Please ask for: Ms Iqraa Malik
Email: iqraa.malik@terraquest.co.uk
Telephone: 0121 234 1390
Our Ref: BR/216/21/HH
Your Ref:
Date: 3rd September 2021

Application for Planning Permission for Works or Extension to a Dwelling

Development: Erection of single storey rear and side extension
Location: 32 Wellington Road Bognor Regis PO21 2RR

Location and Block Plan

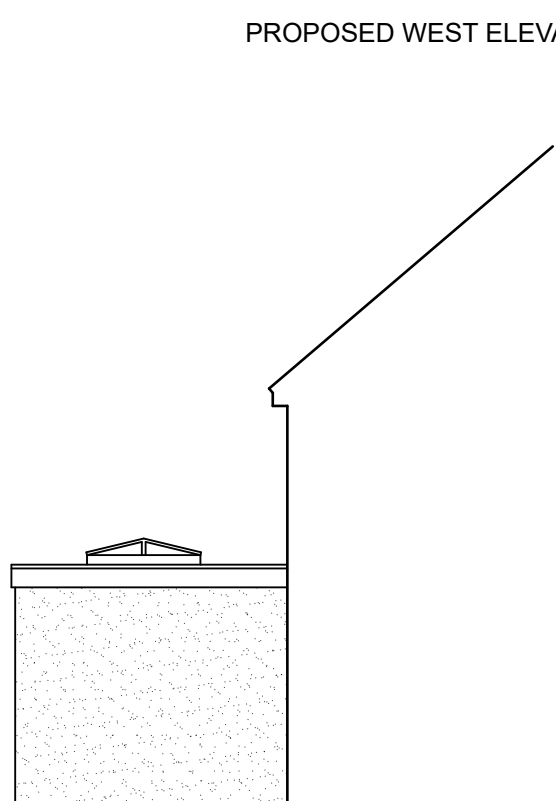
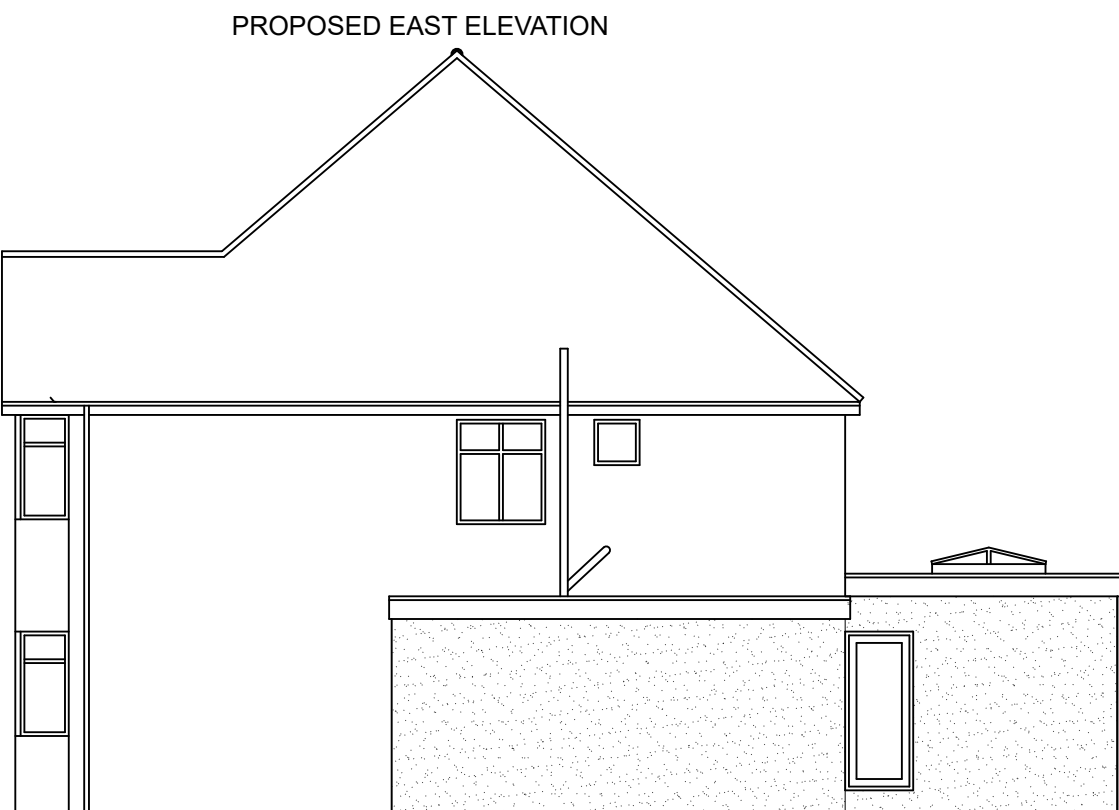
The scale bar on the location and block plans do not measure to scale. Please review and amend.
